COLORADO
Department of Transportation

August 4, 2020

RE: Hwy 94 and Curtis Rd. Map Amendment - CS203

- CDOT Traffic Operations Engineer has reviewed the Traffic Impact Study dated May 27, 2020 by LSC Transportation Consultant, Inc. Their comments are as follows:

Vicinity Map

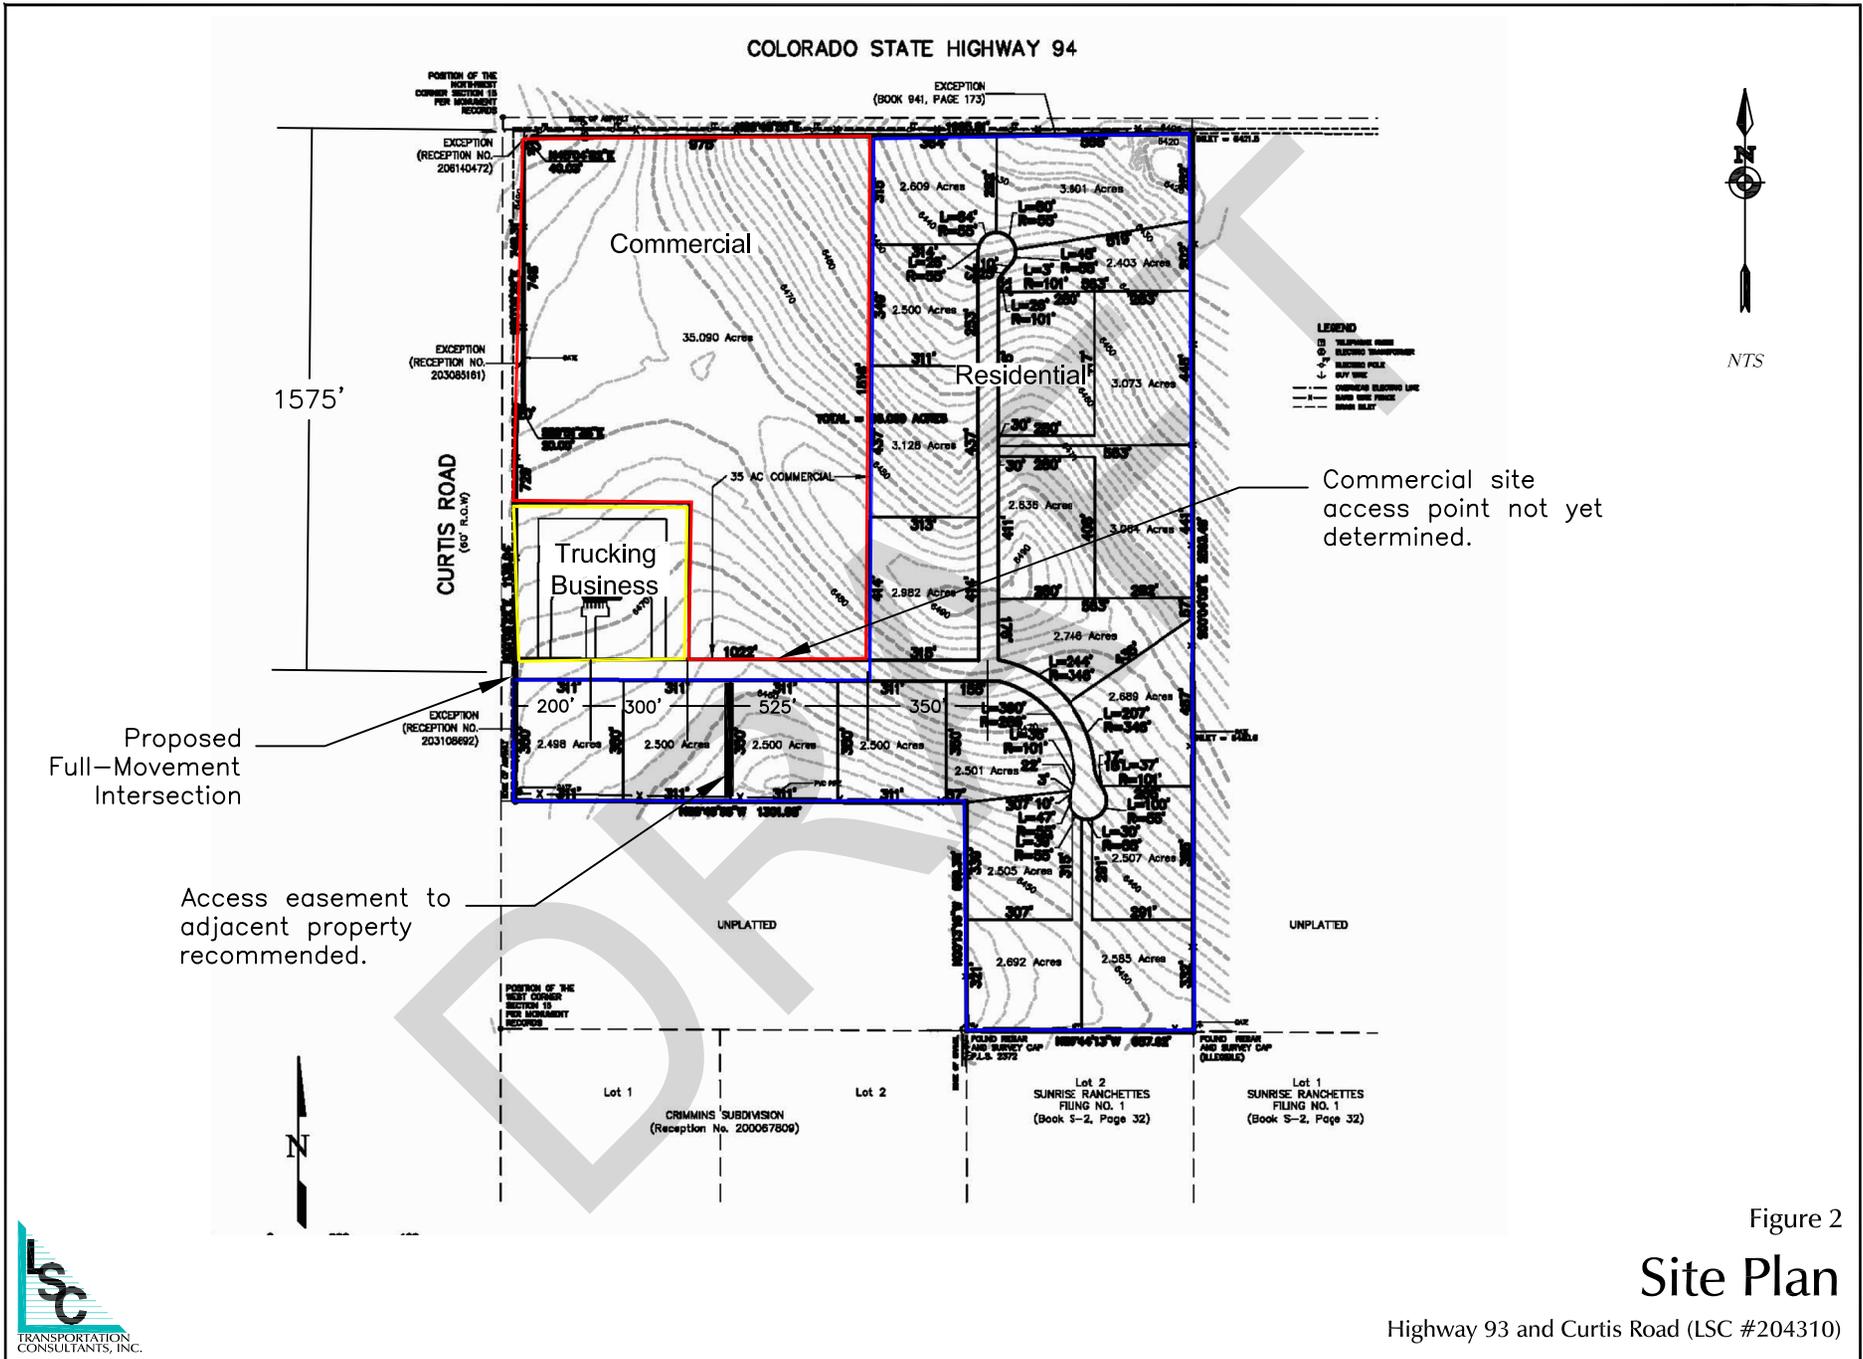
- Trip distribution for commercial uses underweights traffic generation from North Curtis Rd and over-weights traffic from Colorado Springs on Hwy 94.

Short-Term Background Conditions

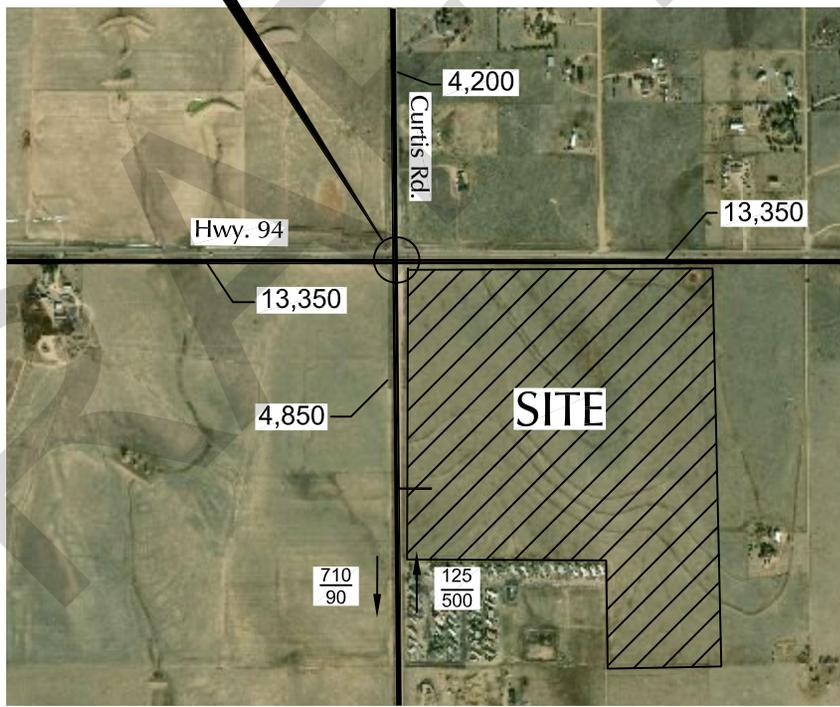
- Growth Factor used to determine background traffic is low for Hwy 94. Recent 2019 CDOT Study of Hwy 94 used 0.62%/yr west of Curtis Rd & 1.51%/yr Curtis Rd to Enoch Rd. It was assumed that Curtis Rd would enable significant traffic from north to the Enoch Rd Gate at Schriever as Falcon grows.

Figure 5

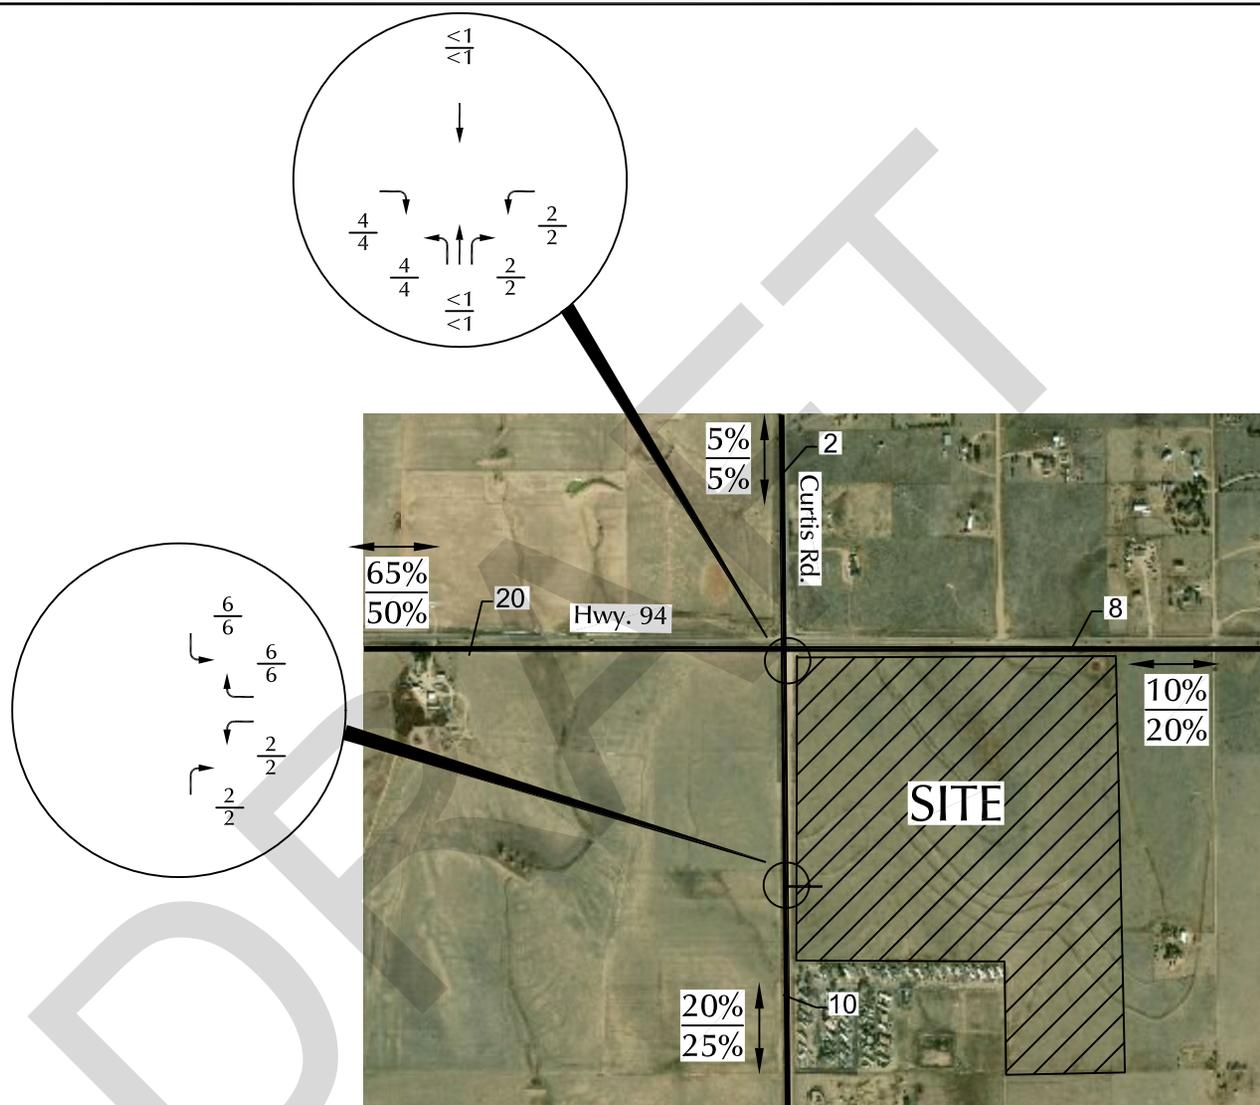
- Double-left turns from Curtis Rd to Hwy 94 are expected by 2040. The El Paso County Major Transportation Corridors' 2060 Corridor Preservation Plan indicated the need for additional thru lanes along Curtis and Hwy 94 after 2040.
